From: Mark Cook
Sent: Thursday, May 17, 2018 9:45 AM
To: Lindsey Ozbolt
Cc: Jennifer Reiner (jreiner@drhorton.com); Candie Leader
Subject: Black Horse

DR Horton's most recent request amending their current phasing plan for Black Horse at Whiskey Creek appears to be acceptable with several adjustments.

Black Horse @ Whiskey Creek Amended Phasing

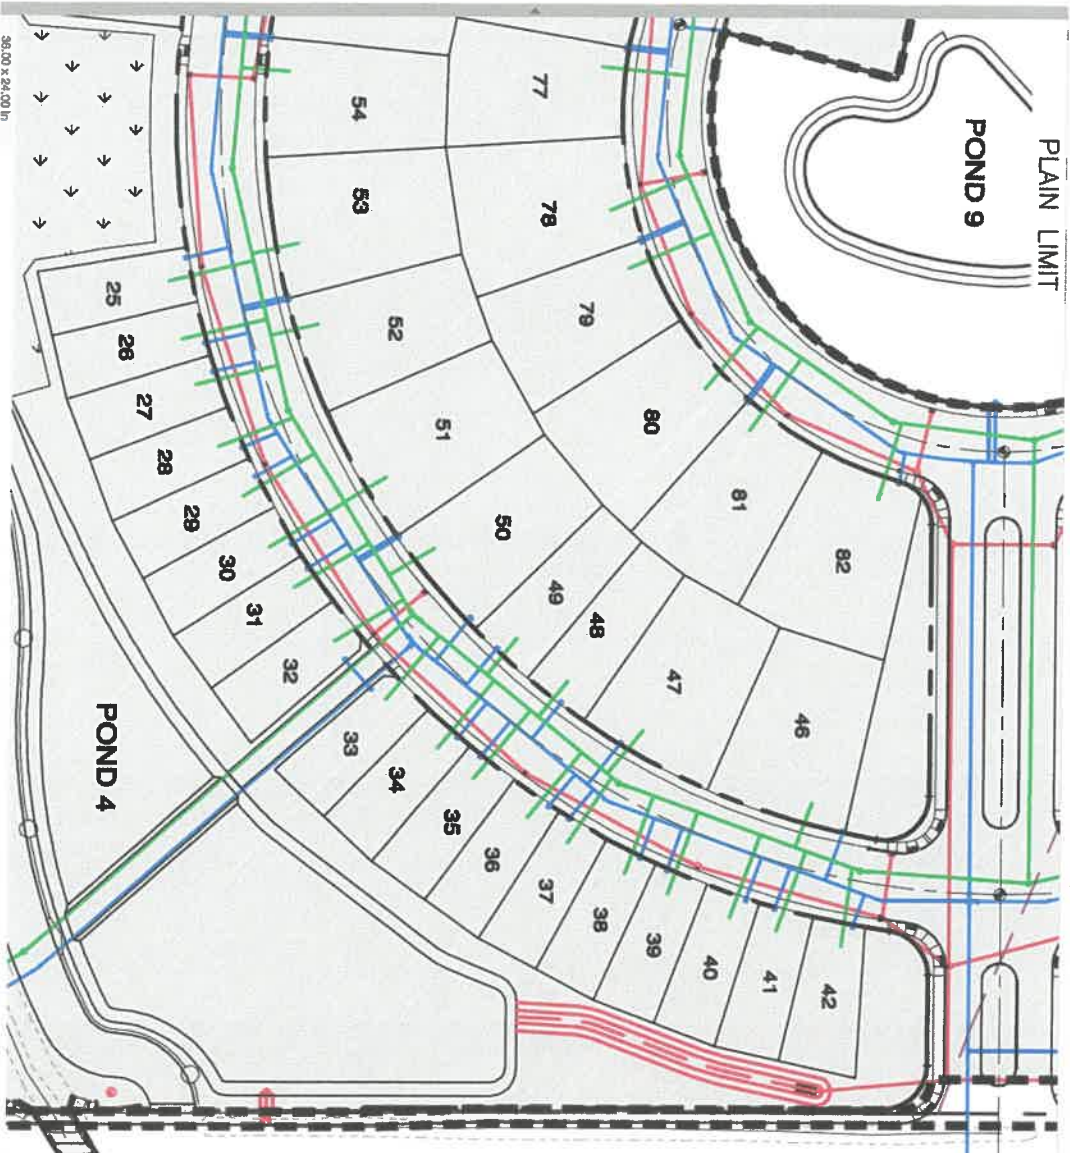
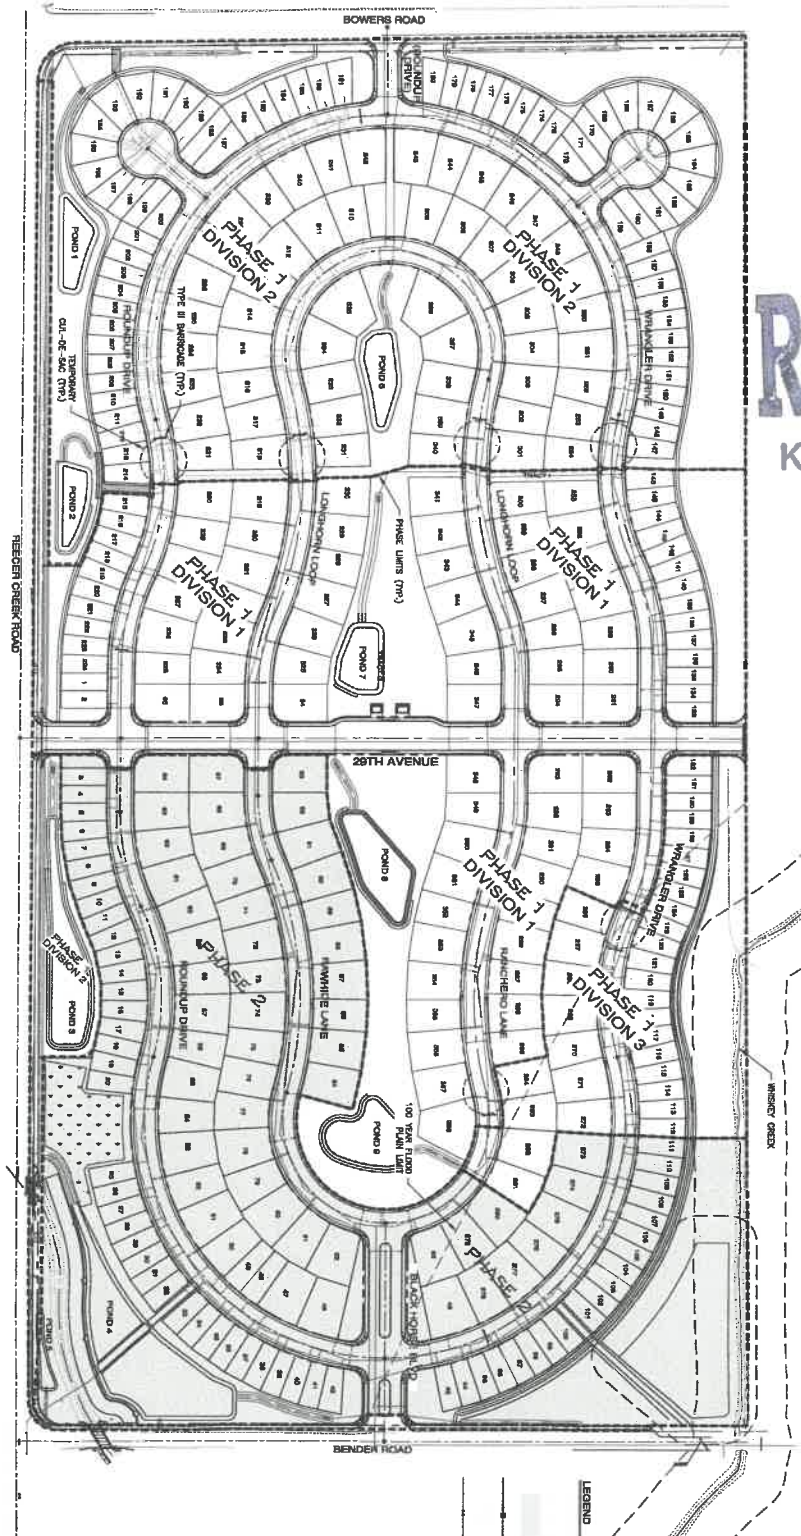
1. Removal of the identified parking lot on Lot 46. Given the unknown nature of that Phase of development (resolving ongoing flood issues in that area of the plat), we prefer the parking lot be removed from requested phasing documents.
2. We also note lots 1 and 2 are missing from the submitted phasing documents.

Public Works is good with the adjustments to the proposed phasing plan as noted above. Regards, Cook.
